**RE: REQUEST FOR FURTHER INFORMATION  
DARLINGTON PUBLIC SCHOOL REDEVELOPMENT (SSD-9914)**

Landscaping and Sightlines

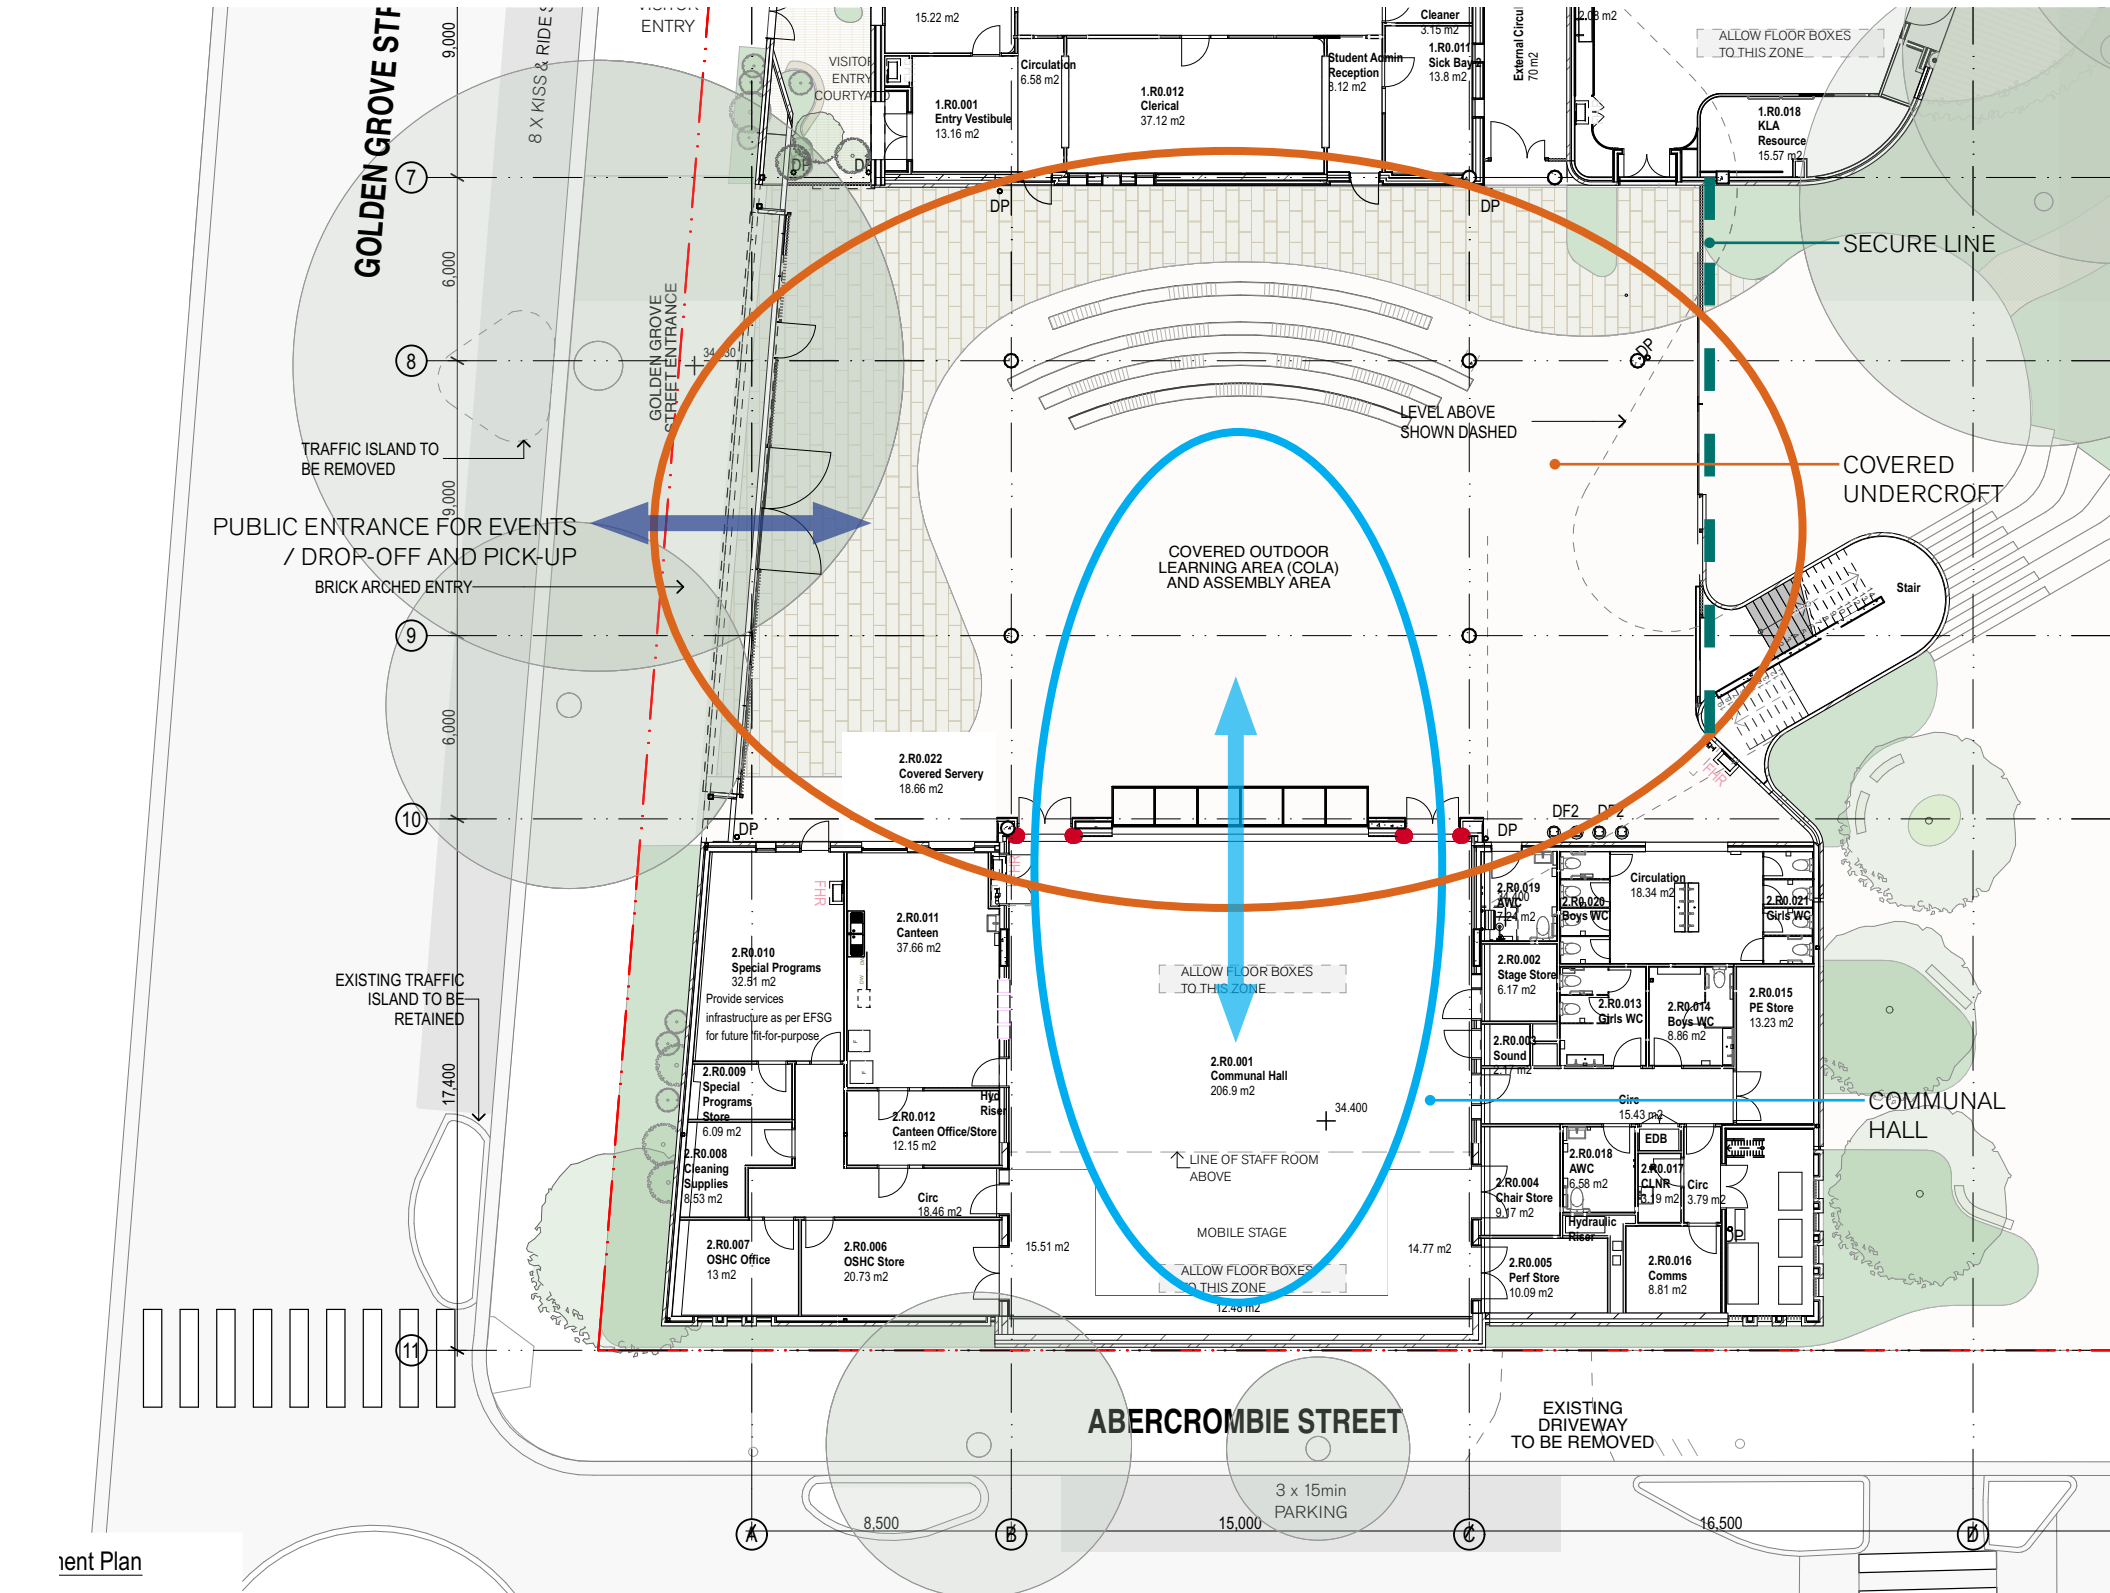
- *The blank wall along Golden Grove street is a poorly considered threshold between the school and public domain and requires further detailing and amenity to be provided.*
